**Dogger Bank South Offshore
Wind Farms**

**The Applicants' Response to East Riding of
Yorkshire Council's Local Impact Report**

Document Date: January 2025

Application Reference: 11.3

Baseline photograph - annotated extent

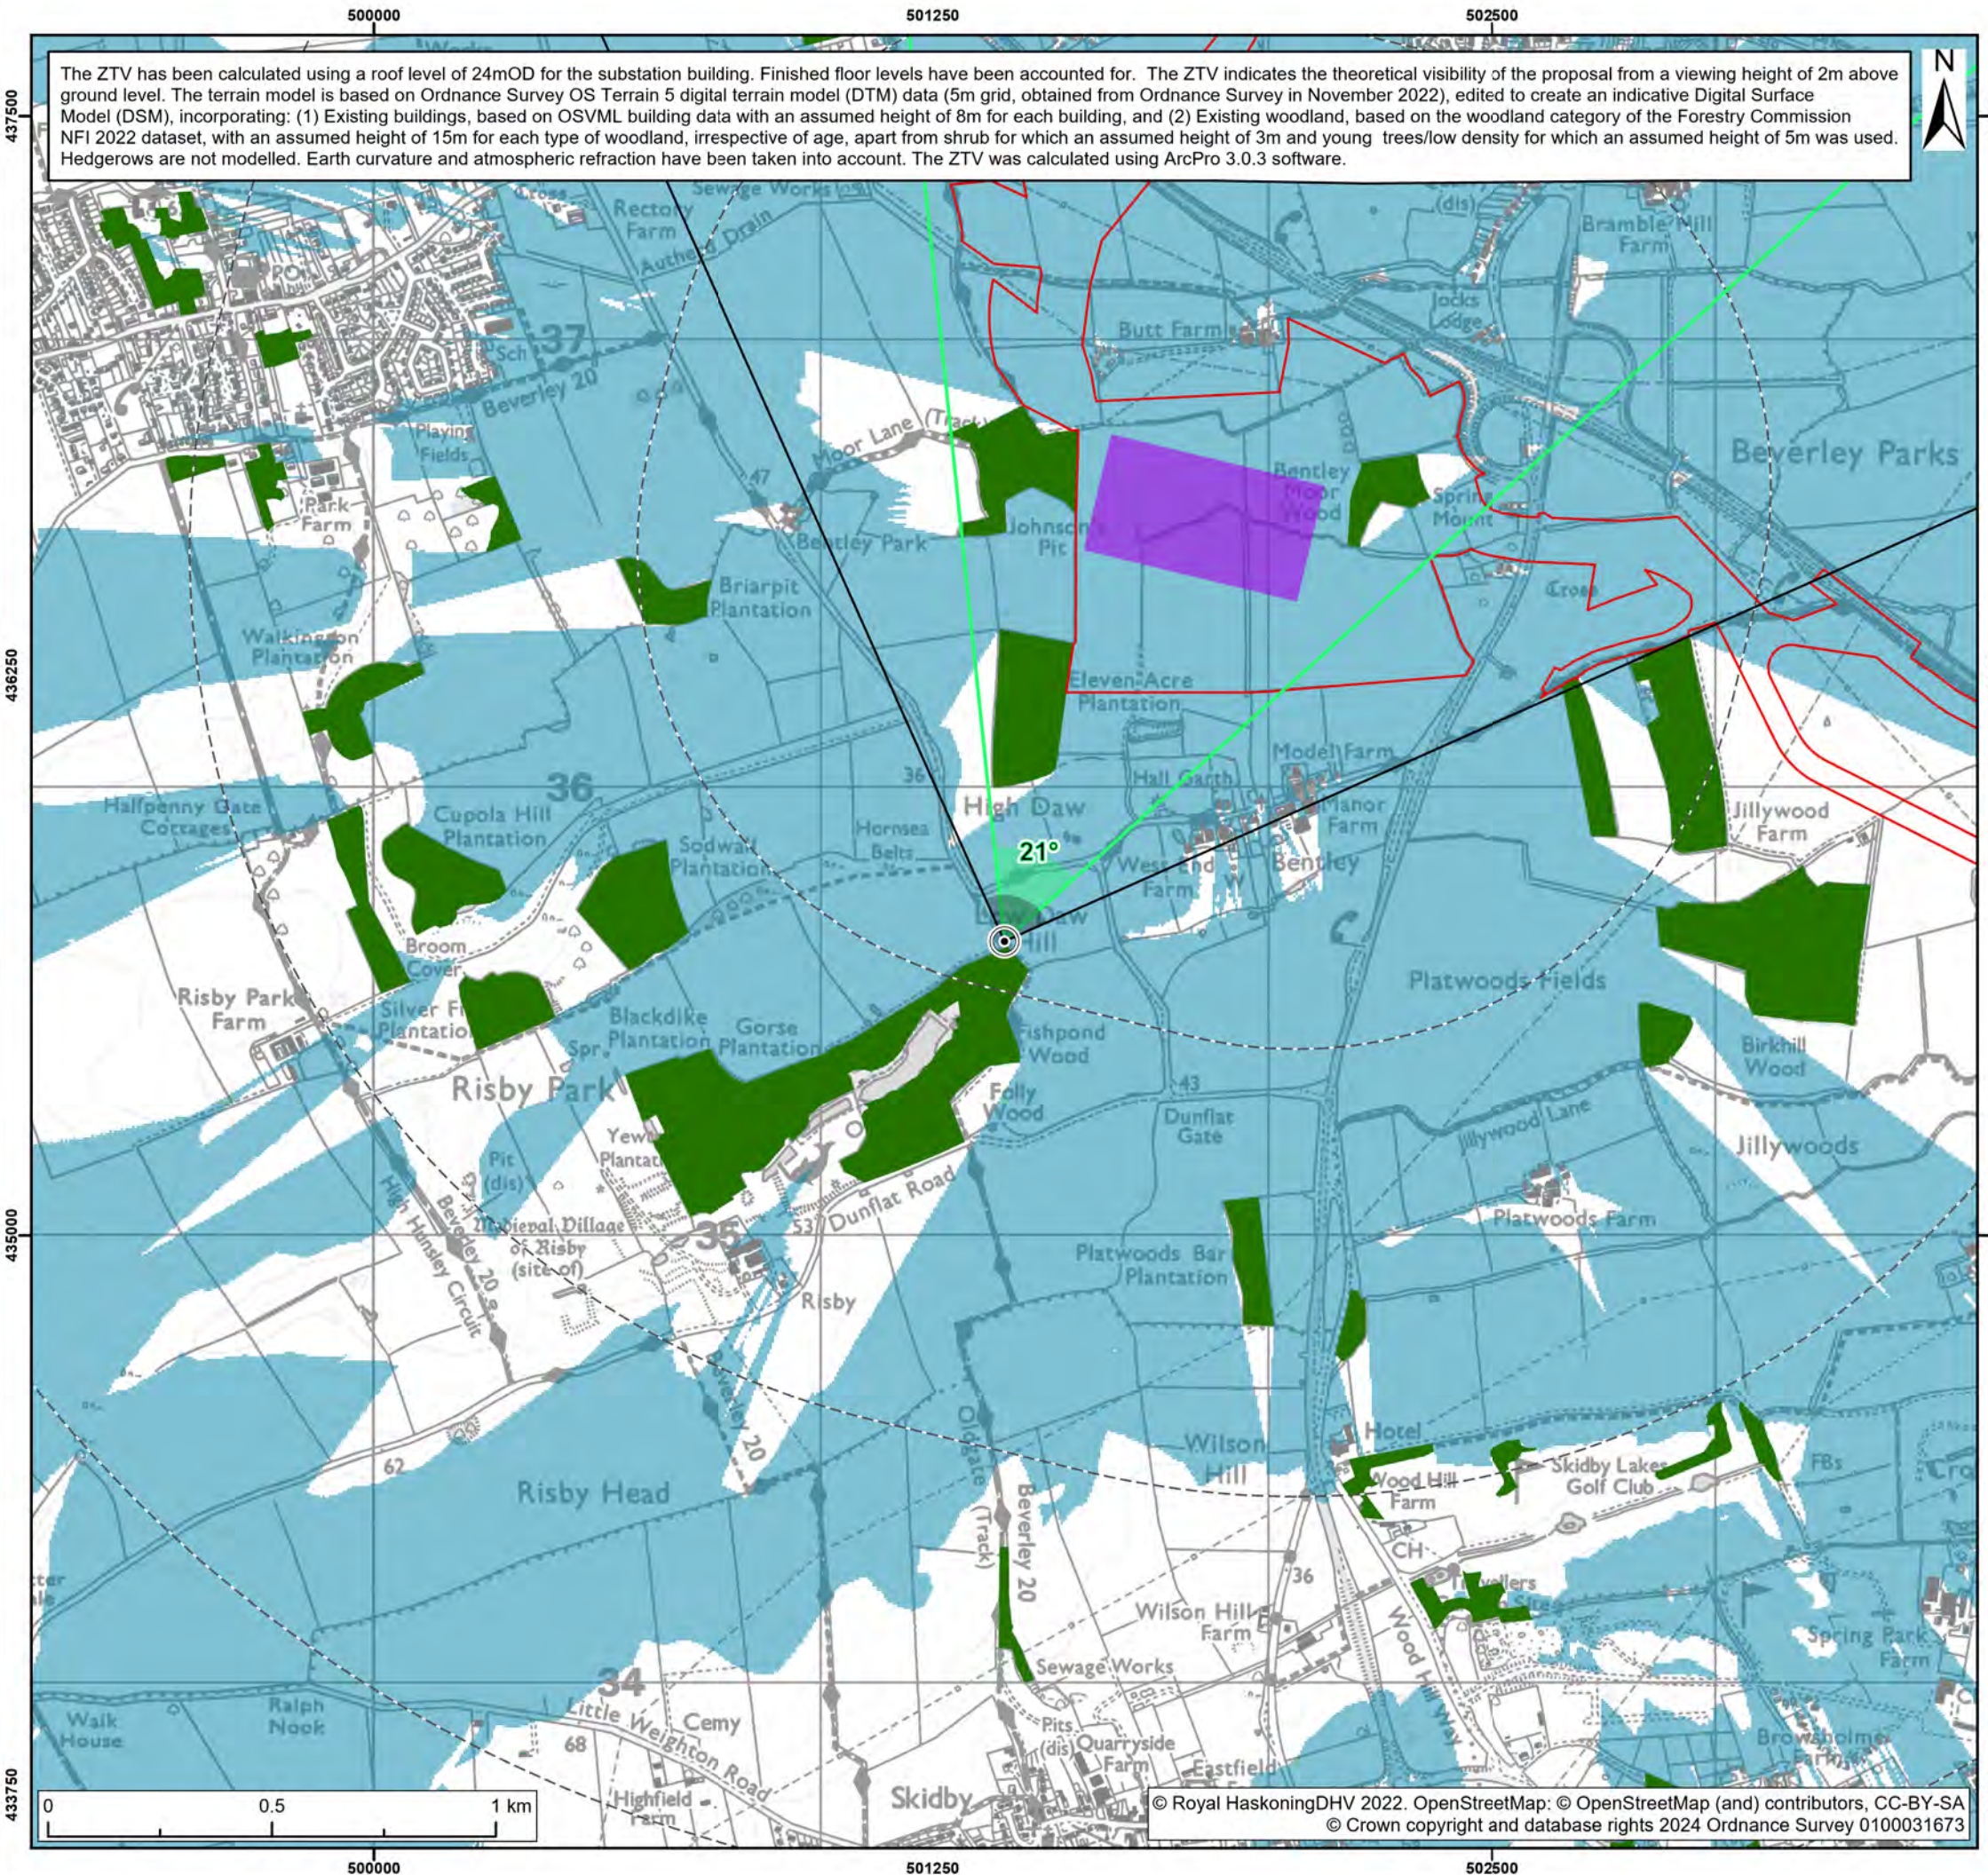
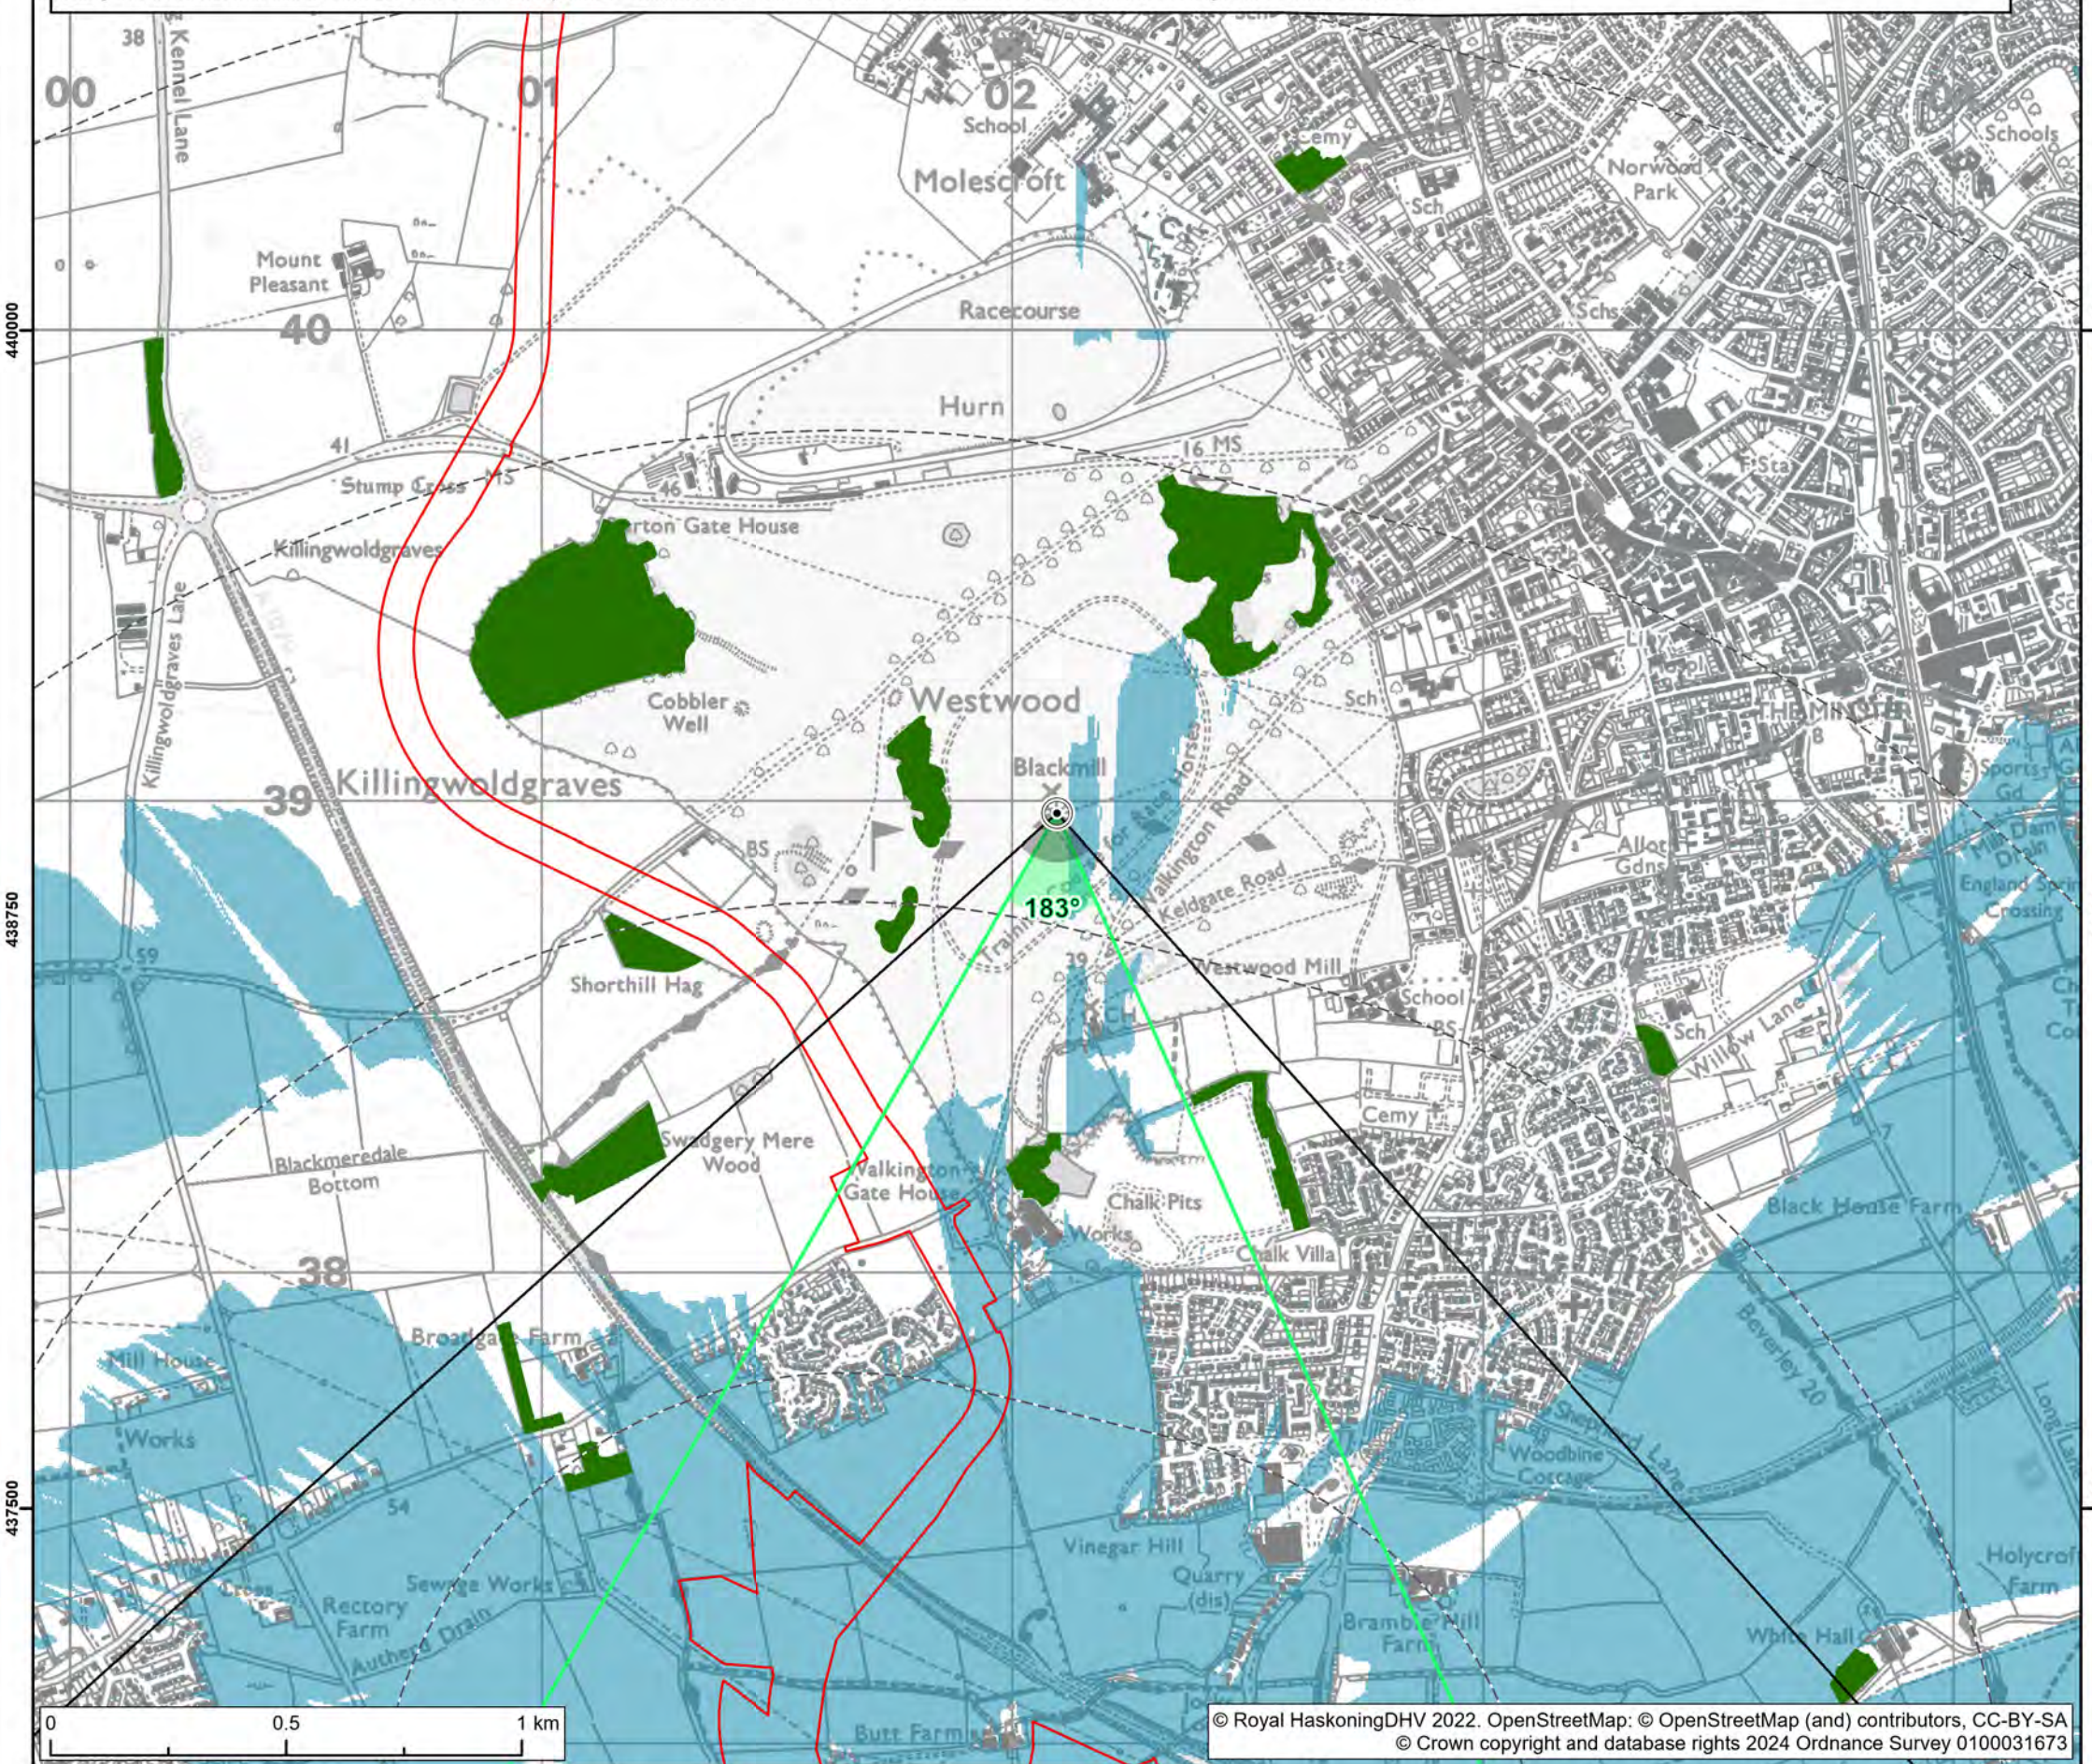
7.11	<p>It was agreed at pre-application stage that the photomontage for Viewpoint 3 would be updated to illustrate earthworks along the access track. This visualisation is presented as Figure 23-9 in Volume 7 (application ref:7.23.1). This has been done, however comparing VP3 to the plan and LVIA text two points arise:</p> <p>a. The ten-year view does not indicate any screen planting to the north of the sub-station, which is shown on the Indicative Landscape Plan</p> <p>b. The LVIA (para 233) notes that: <i>A TCC [Temporary Construction Compound] would be located immediately adjacent to the viewpoint throughout the construction works...</i> The Works Plan (Onshore) Page 18 of 19, also shows a Temporary Construction Compound occupying much of the field to the right-middle-ground of Viewpoint 3. This suggests that the construction effects could usefully be illustrated from this viewpoint.</p>	<p>The Year 10 visualisation for Viewpoint 3 does include mitigation planting to the north of the Onshore Converter Station. This is difficult to see in the image for two reasons:</p> <ol style="list-style-type: none"> 1. The topography rises from the viewpoint, then falls towards the onshore converter station. The screen planting would be located at a point lower than the foreground topography, and along with the lower parts of the onshore converter station would be partly out of sight. 2. The photograph shows a winter view. During winter, deciduous planting would lose its leaves, reducing its screening function. The upper branches of mitigation planting are shown in the visualisation but are not clearly visible due to distance and the scale of the image on paper. <p>The screen planting would be more visible during summer, and would continue to mature beyond Year 10, increasing its screening effect in the long term.</p> <p>As part of the Project Change Request 2 [AS-152], the Onshore Converter Stations will be reduced in extent, and the massing will be less visible in this viewpoint. Updated visualisations showing the revised Onshore Converter Station will be presented at Deadline 2.</p> <p>An additional visualisation for Viewpoint 3 showing the extent of the Temporary Construction Compound, and a 2.5m fence, forms Appendix A of this document.</p>
